Application for Removal or Variation of a Condition following Grant of Planning Permission or
 Listed Building Consent

Erection of a two storey dwelling following demolition of existing bungalow.

23/00079/FUL

Condition 2

DRAWING NO.
 19DA-PL-02-NE

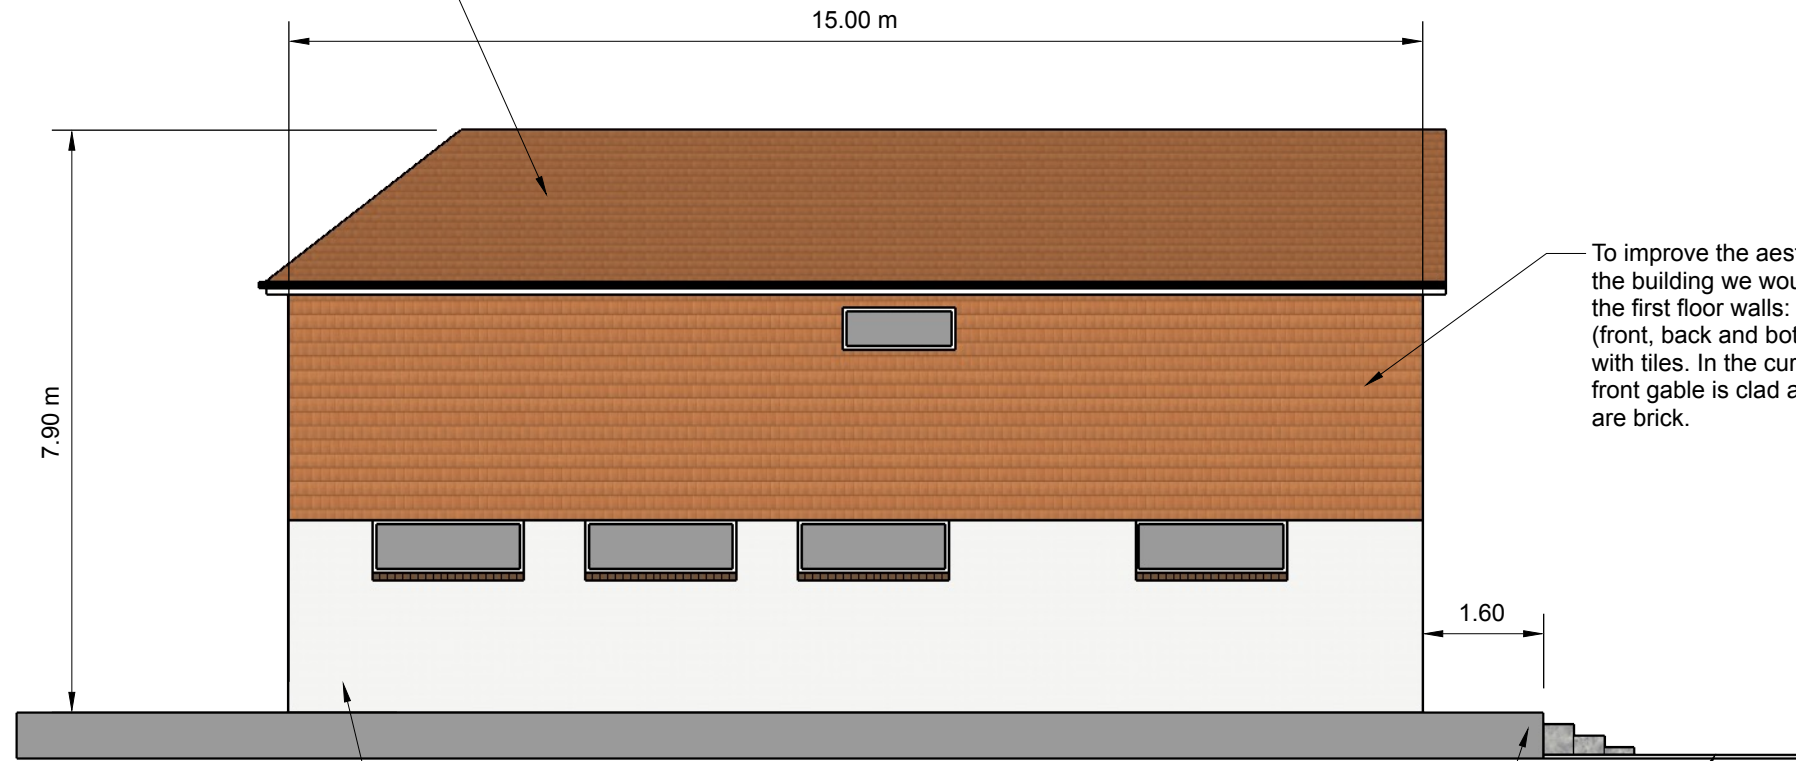
- 1) We would like to reduce the amount of light disturbance to 17 Downs Avenue by incorporating a hipped roof design with sunken table-top GRP flat roof.

- 2) With consideration to the feedback received during the council planning meeting on 8th of June 2023, we would like to enhance the aesthetic appearance of the proposed property (and especially the North facing wall between 17 and 19) by modifying the design to incorporate clay tile cladding on the upper portion of all four elevations of the main dwelling.

- 3) To improve the aesthetics and thermal efficiency of the new building we would like to feature a white rendered finish on the ground floor. There are many other houses on Downs Avenue that follow this design pattern and a selection of these homes are shown in the additional information document (19DA-PL-08-AI) included with this submission. Please note that, the proposed materials list remains unchanged.

- 6) In response to privacy comments from number 17 we would like to reduce the front walkway from 3.6m to 1.6m and will no longer be used as a patio. Instead, we propose that we build a 3.6m patio at the edge of the lawn.

2) We would like to update: 19da-PE-001 / Rev 1 to:

- 19DA-PL-01-FE Rev 0 "Front Elevation"
- 19DA-PL-02-NE Rev 0 "North Elevation"
- 19DA-PL-03-RE Rev 0 "Rear Elevation"
- 19DA-PL-04-SE Rev 0 "South Elevation"

to show the i) new hipped roof, ii) the proposed white rendering with clay tile cladding to all four elevations, iii) the revised front wall under the porch, and iv) the revised walkway width on the front elevation with ground level patio.

DRAWING TITLE
 South Elevation
DRAWING NO.
 19DA-PL-04-SE

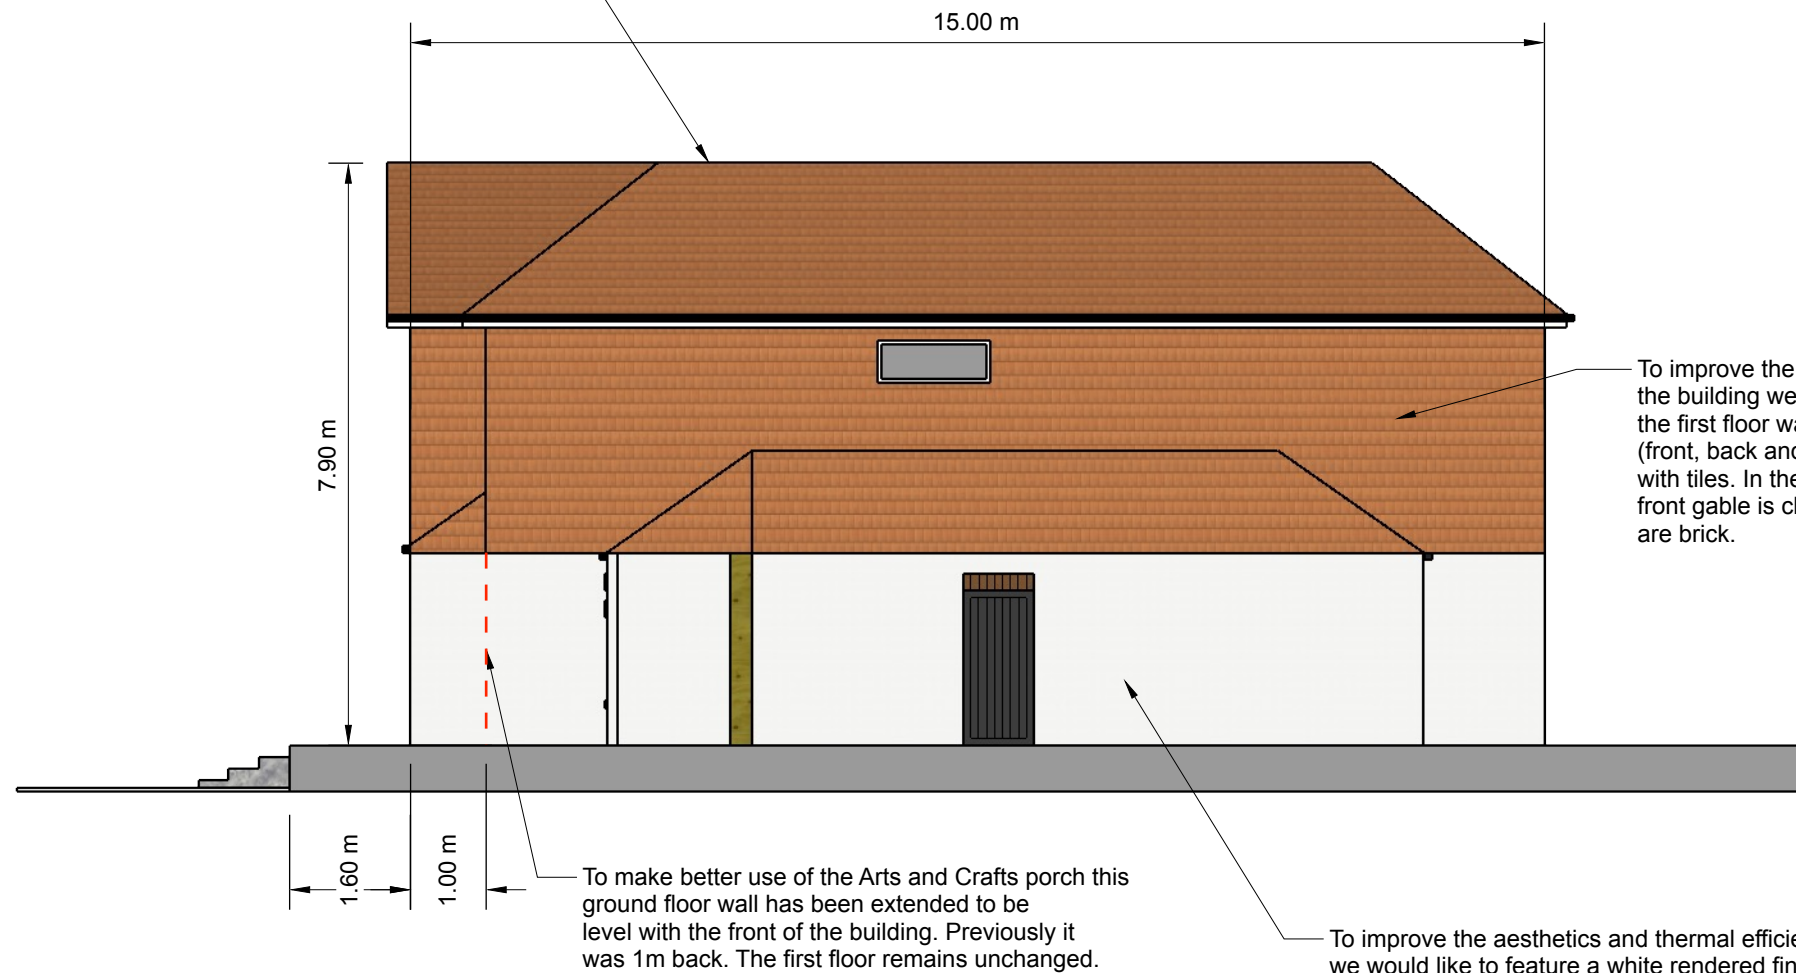
- 5) To make better use of the Arts and Crafts Porch, we would like to extend the wall to the right of the front door (when facing the building), forwards by 1m so that it is level with the front of the building. The first floor will remain unchanged. Please refer to drawing 19DA-PL-01-FE.

**DRAWING TITLE**  
 First Floor Plan  
**DRAWING NO.**  
 19DA-PL-07-FF

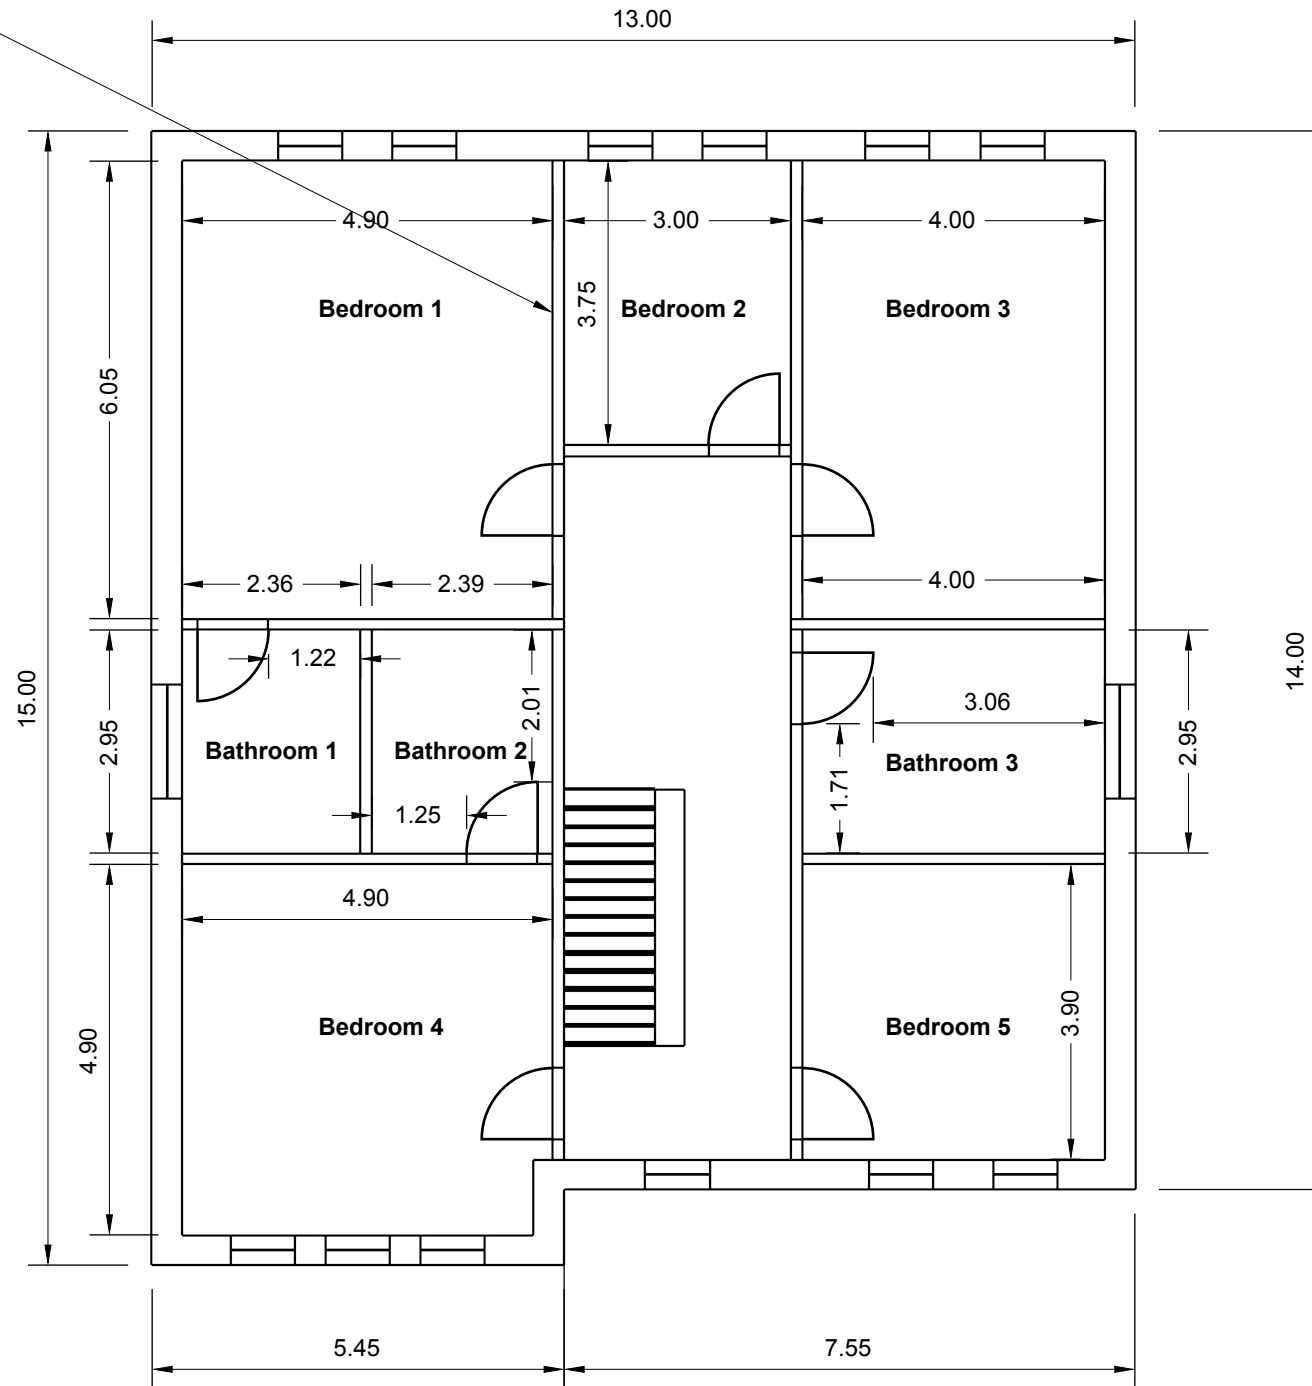
- 7) To improve the structural integrity of the building, we would like to revise the first floor layout slightly. This will effect Bedrooms 1 and 2.

4) We would like to update: DA-FP-001 / Rev 0 to:

- 19DA-PL-06-GF Rev 0 "Ground Floor Plan"
- 19DA-PL-07-FF Rev 0 "First Floor Plan"

to show the new proposed plans for: i) the revised front wall under the porch, and ii) the revised floor plan on the first floor.
